9 Portland St.

Renovations

Preble St. Resources

**From:** Marge Schmuckal  
**To:** Kandi Talbot  
**Date:** Tue, Apr 29, 2003 11:38 AM  
**Subject:** 9 Portland Street - Preble Resource Center

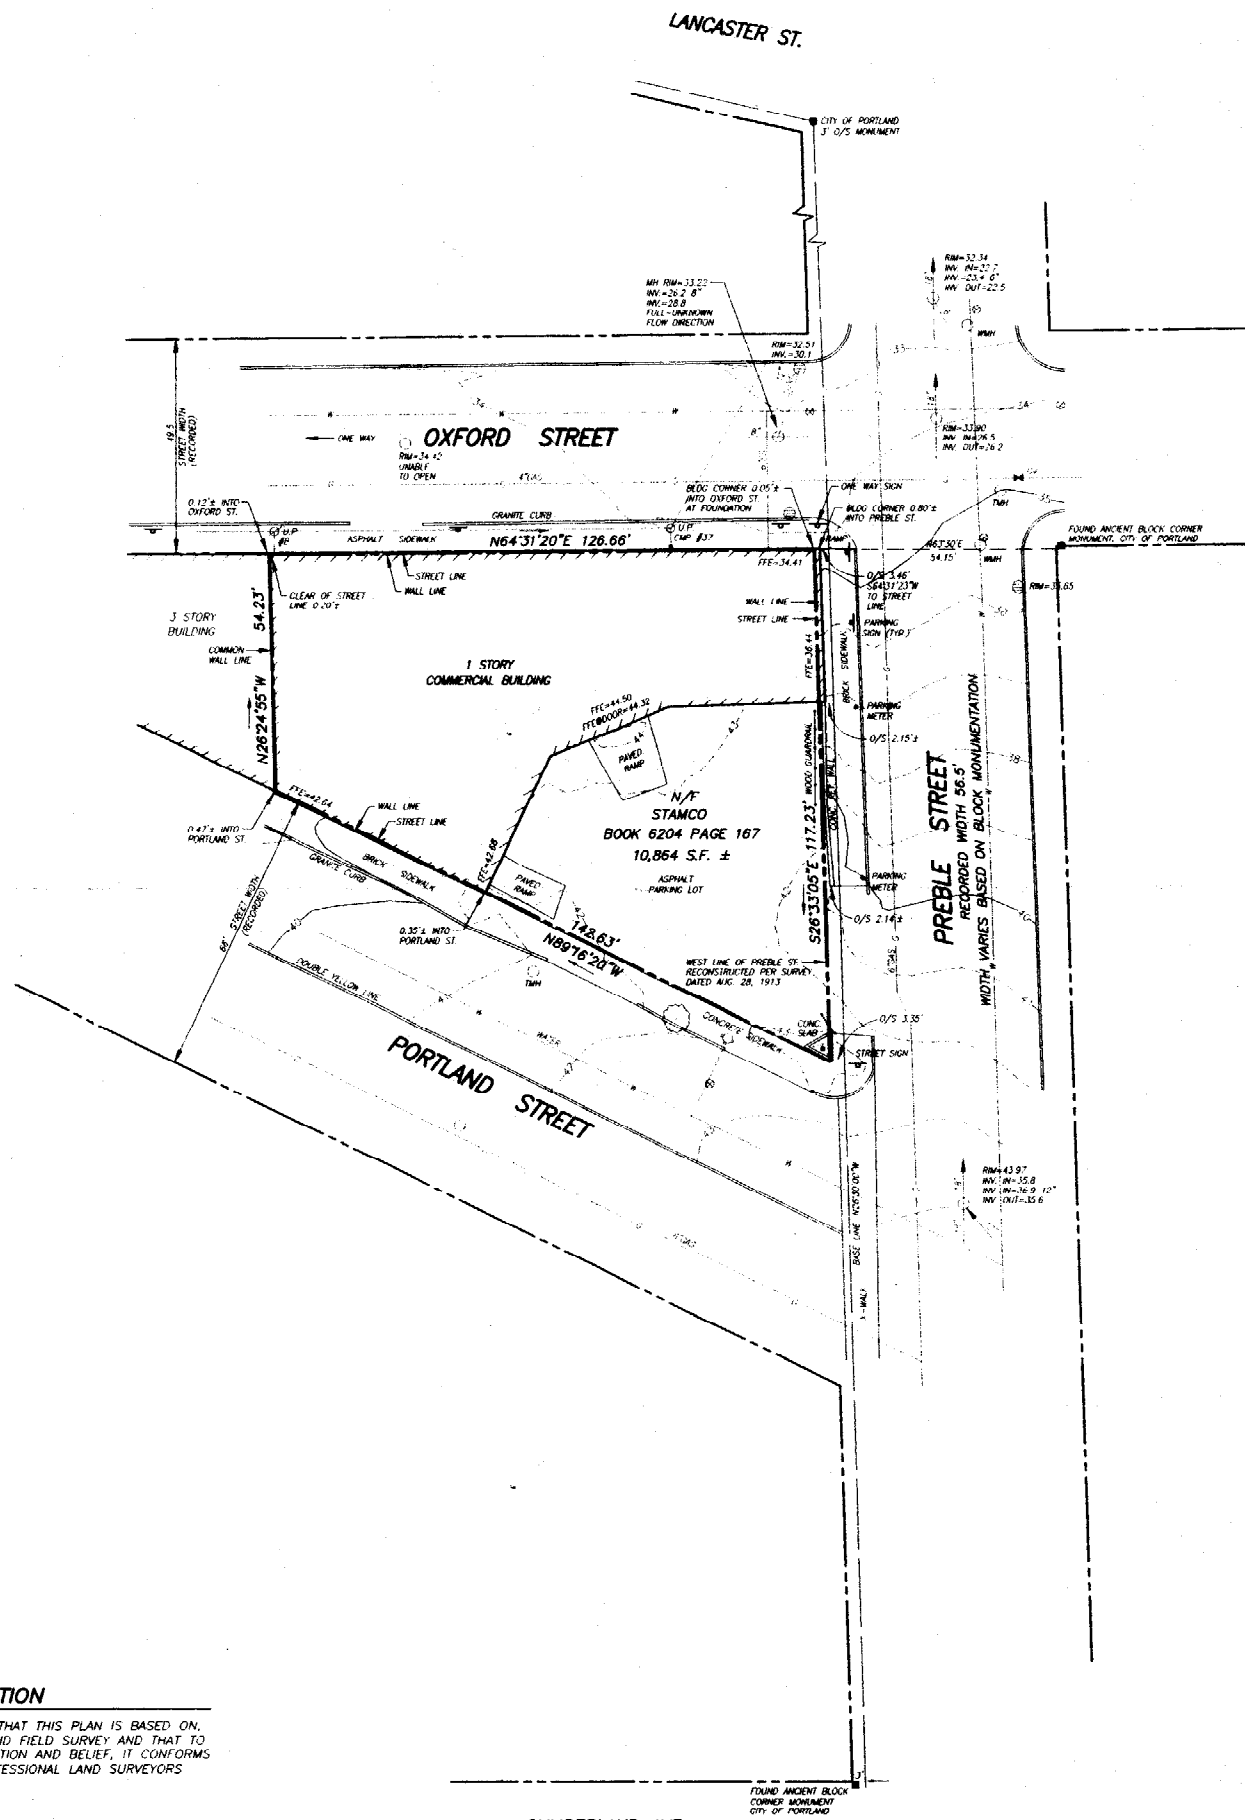
I also do not see actual lot lines shown on the site plan. On both Preble and Portland Streets, the plans are labeled that the addition is set back to property lines. But the building looks setback to some other given line. Don't you require actual property lines to be shown on submittals?

<p>PSRC 5 portland street portland, maine</p> <p>owner: preble street resource center portland, maine</p>	<p>architect: james sterling, aia 142 high street portland, maine</p> <p>upper level renovations</p>	<p>date: 22 april 03 revision:</p> <p>scale: 1/4" = 1'-0"</p> <p>sheet A- 1.1</p>
---	--	--

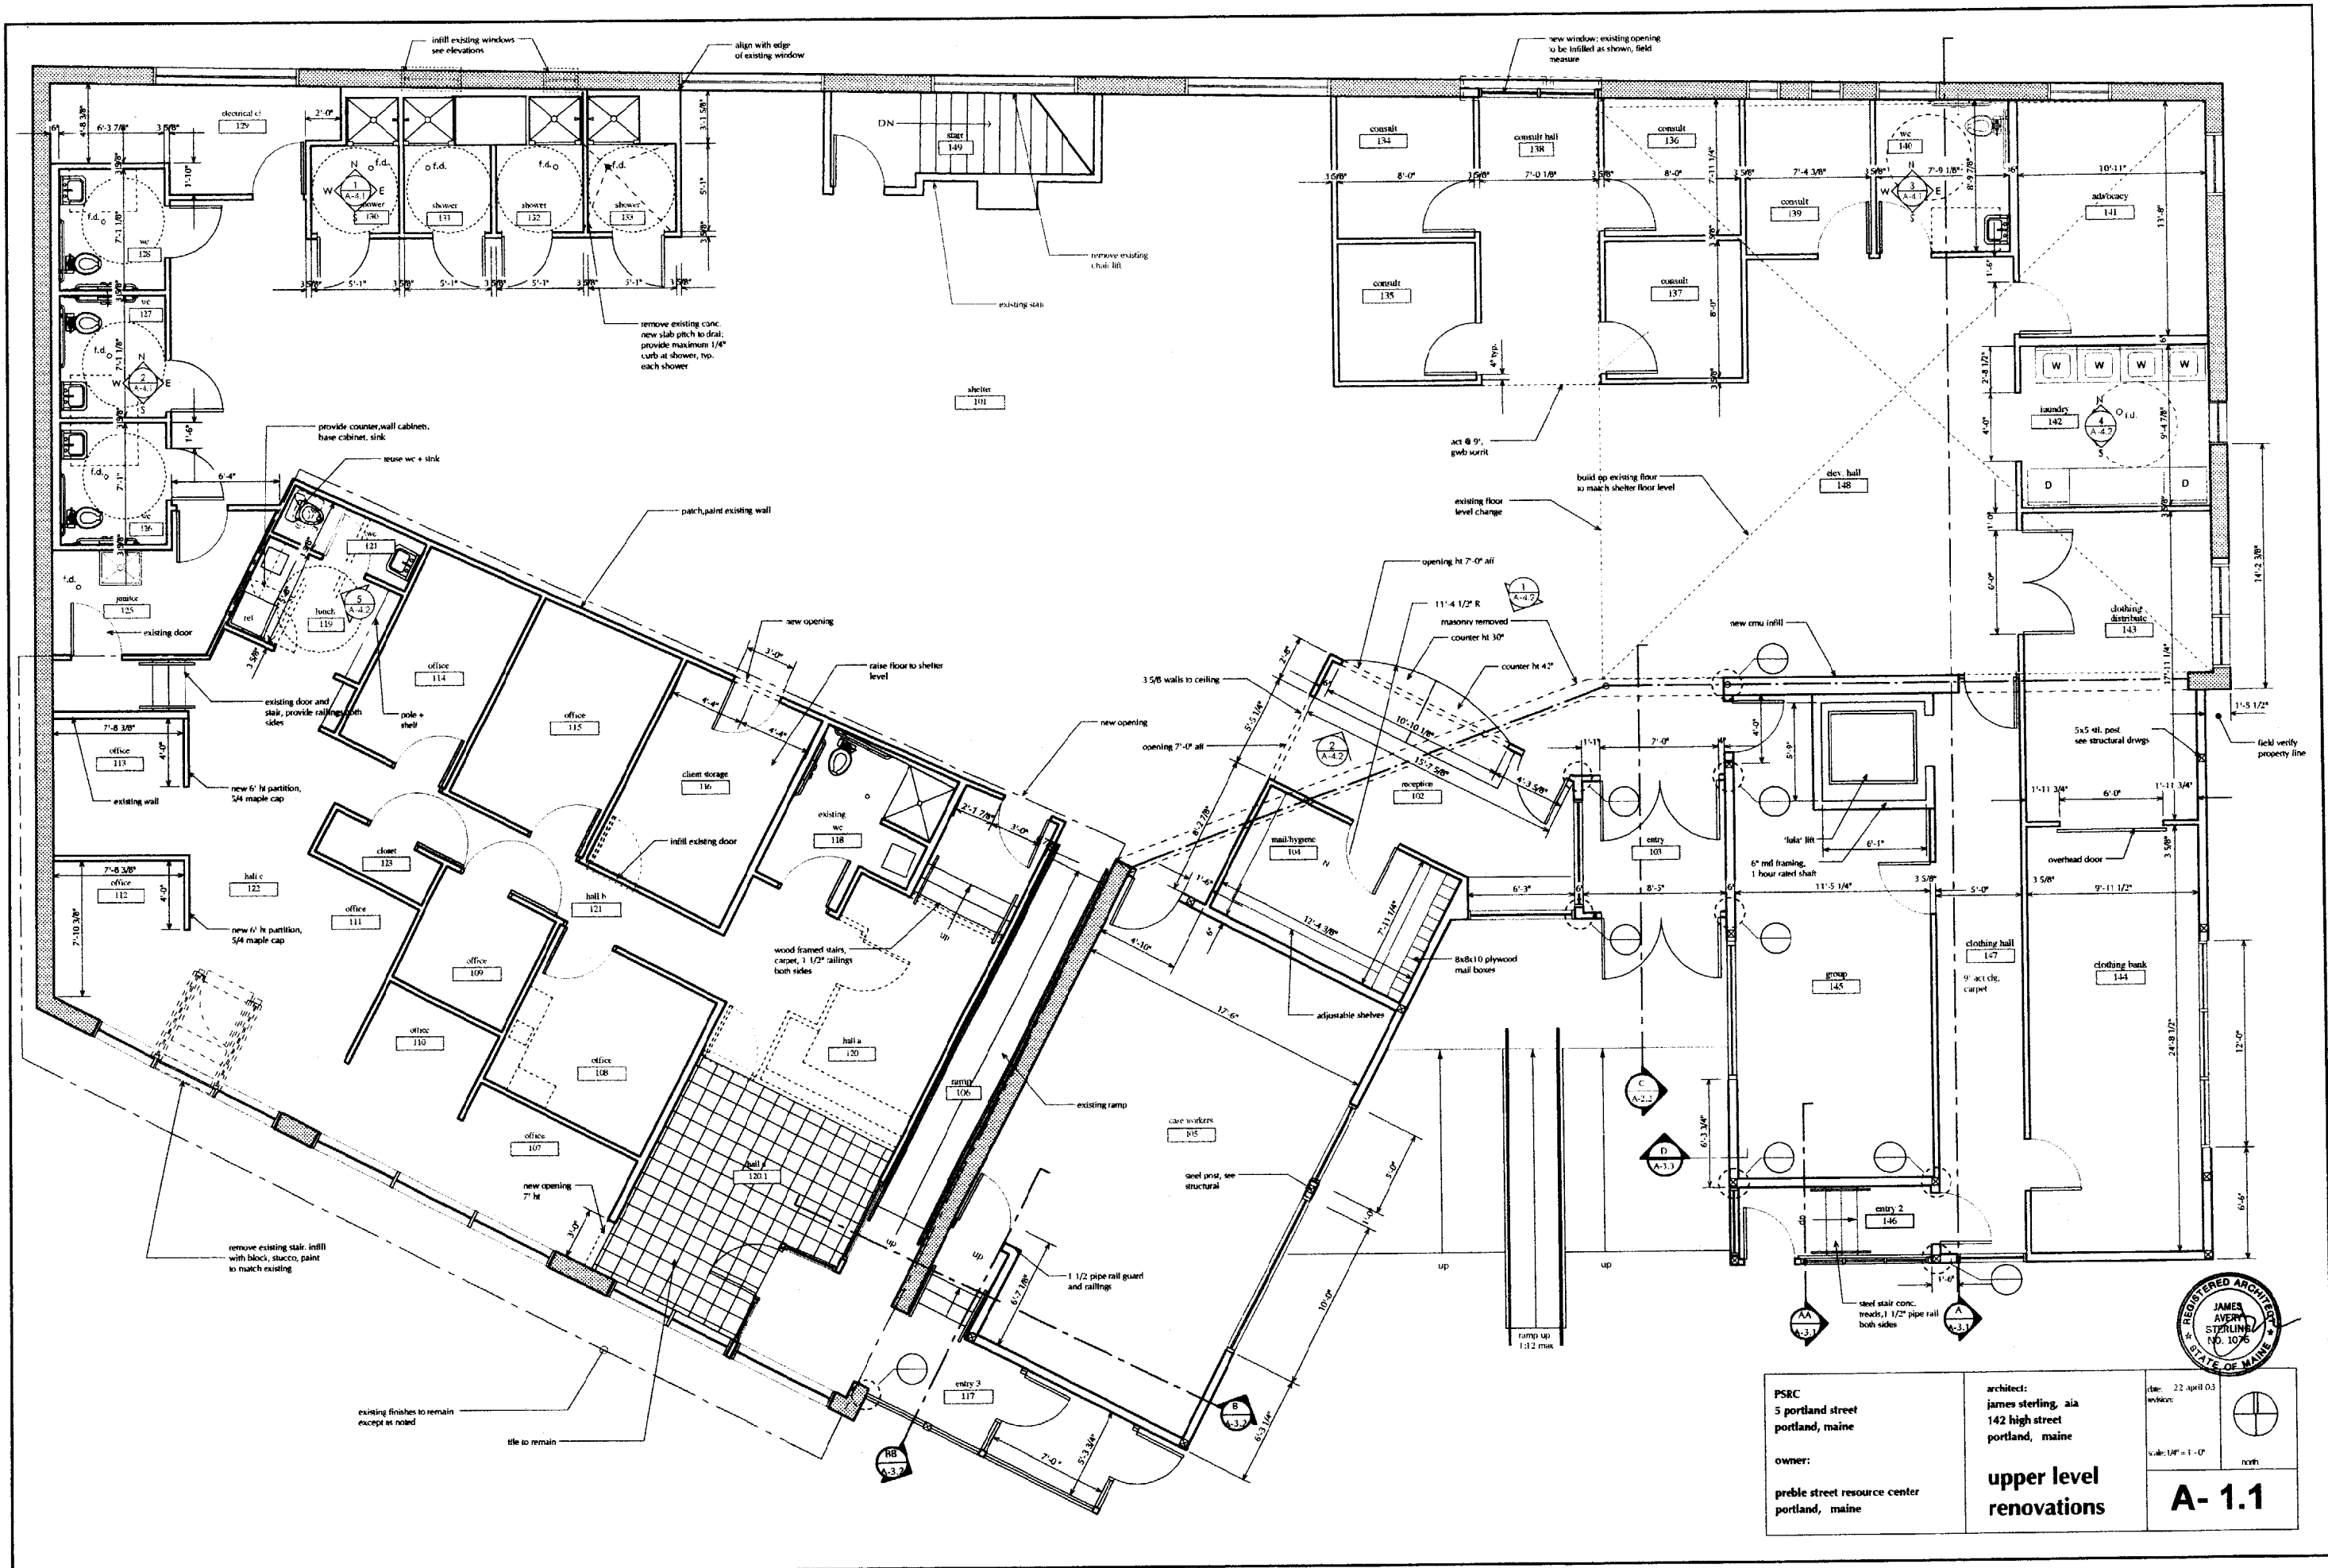
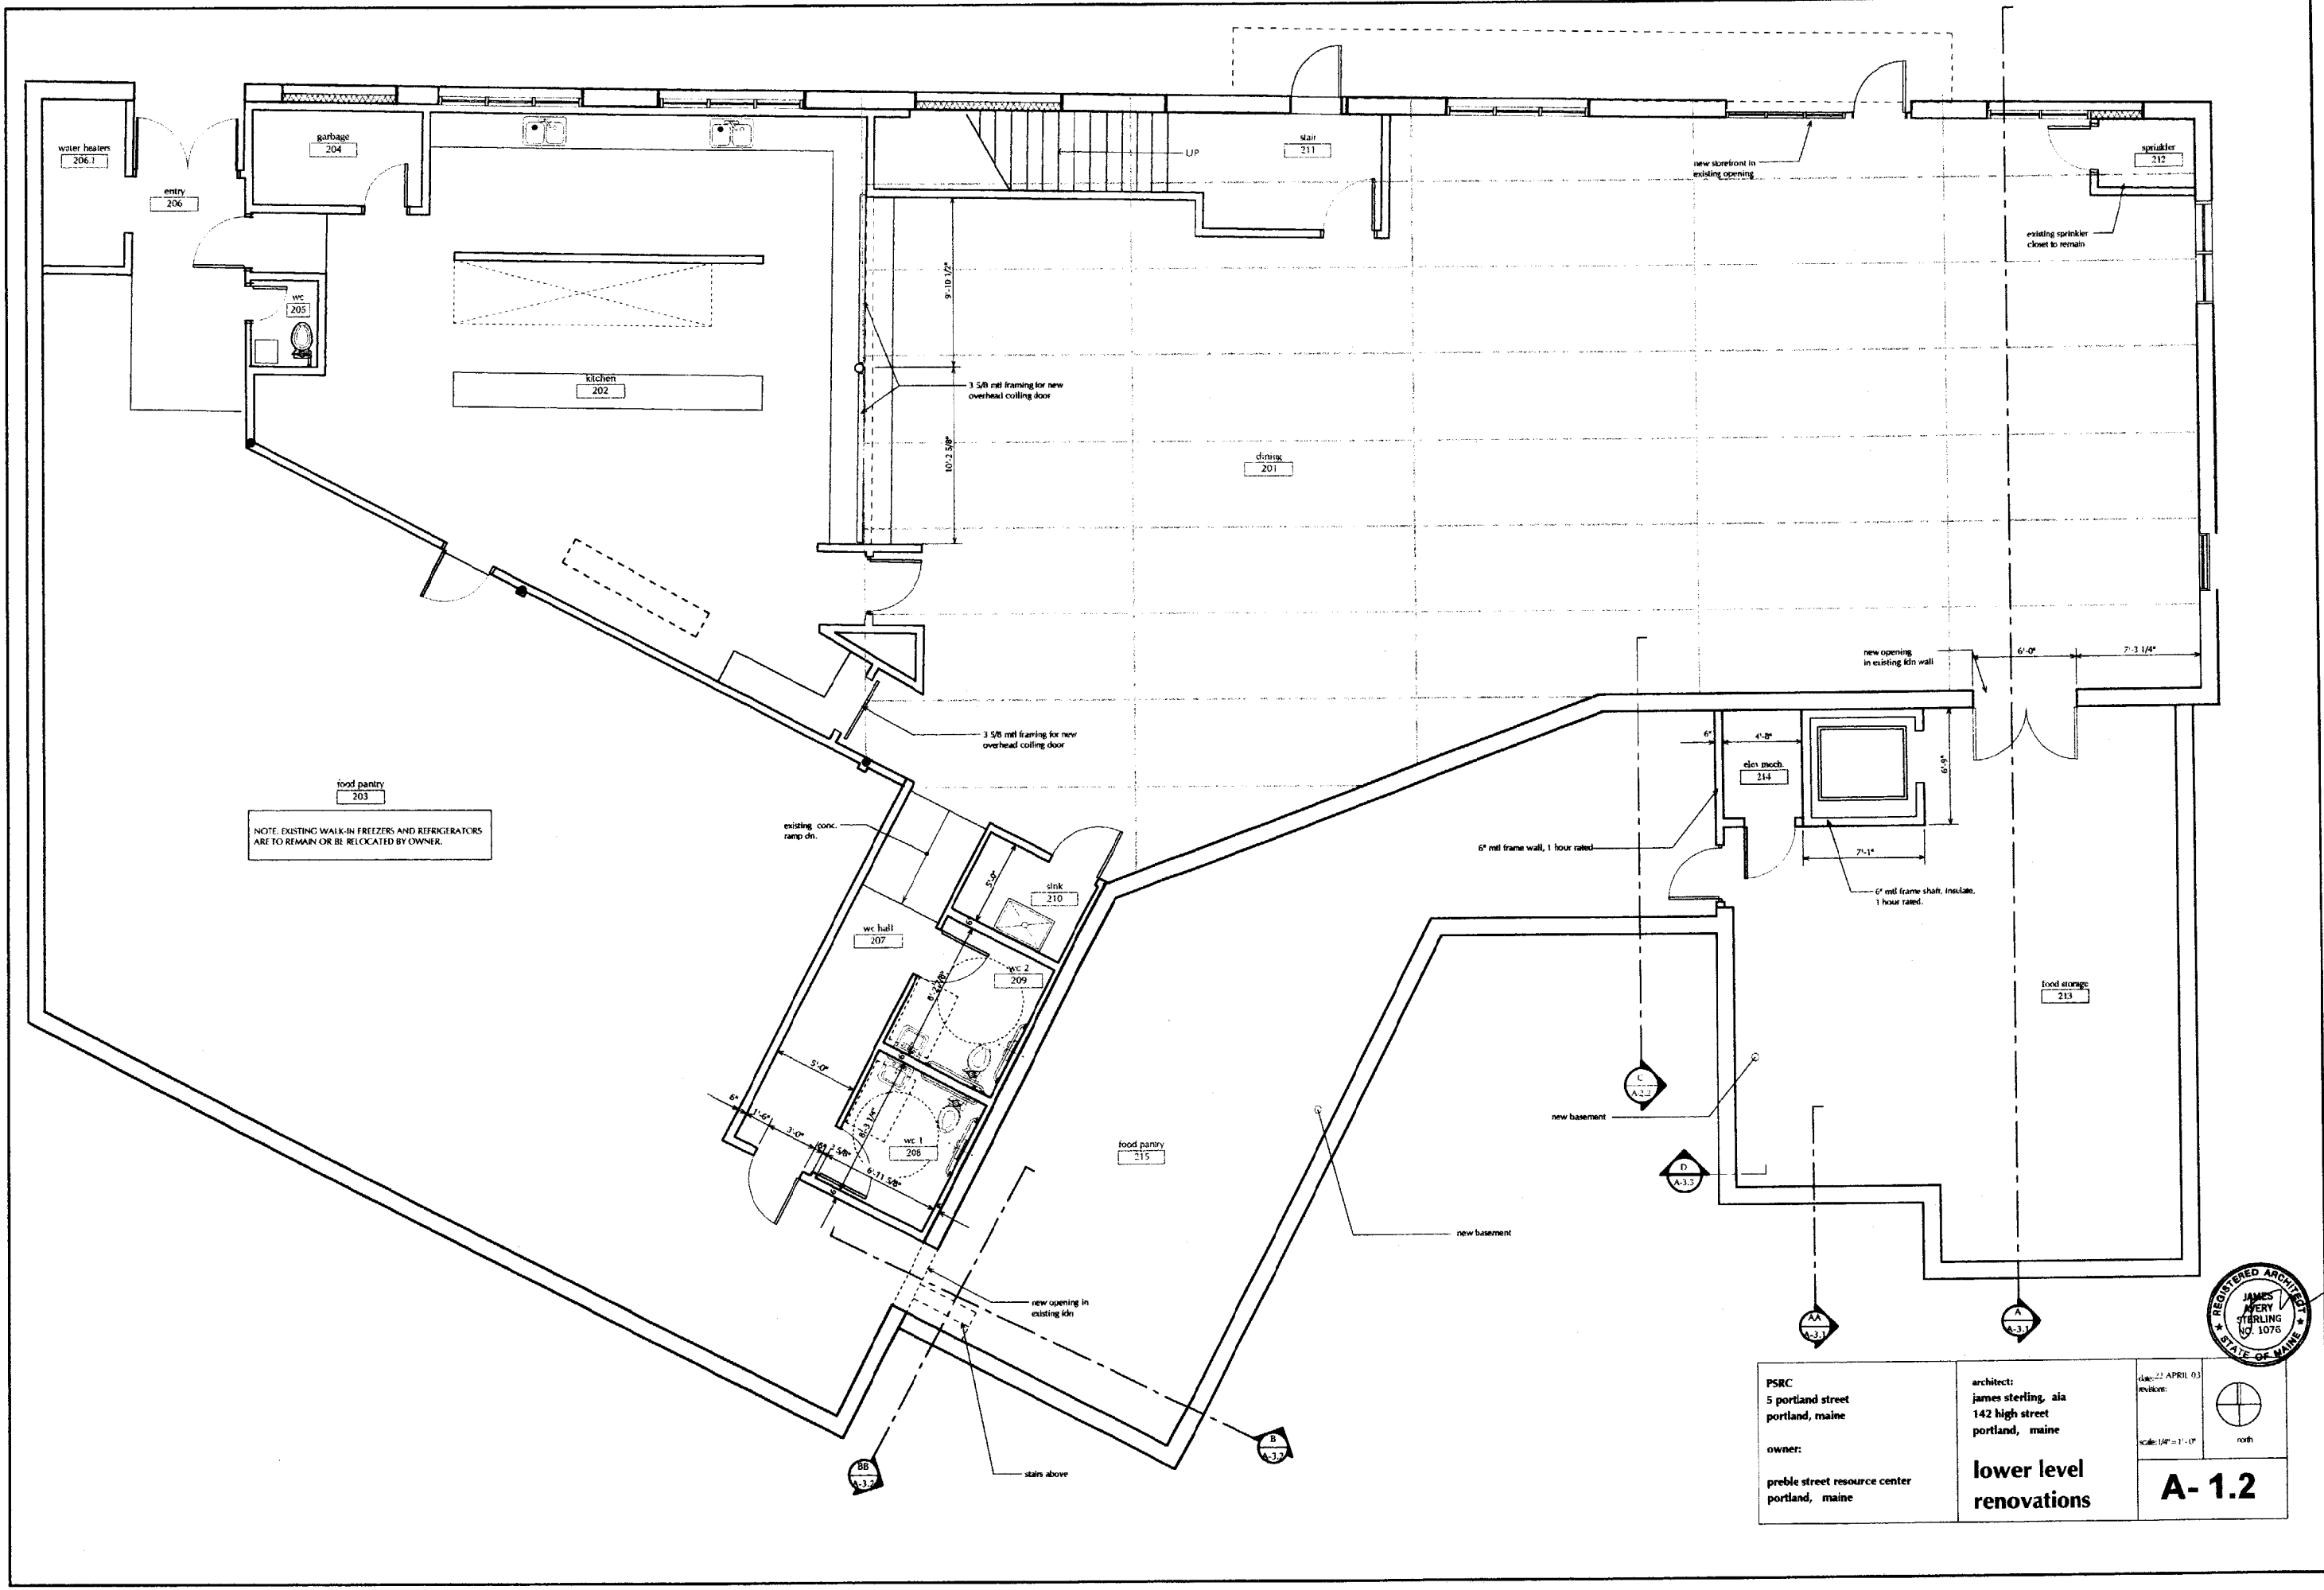
I am also uncertain as to parking requirements. I need some clarification as to labeled uses shown on the plans. On the upper level renovation area that is labeled "coordinaters", is that office space? Is the "clothing bank" area a public assembly area? On the lower level renovation area, what is the food pantry area? Is it a public assembly area, or is it a storage area?
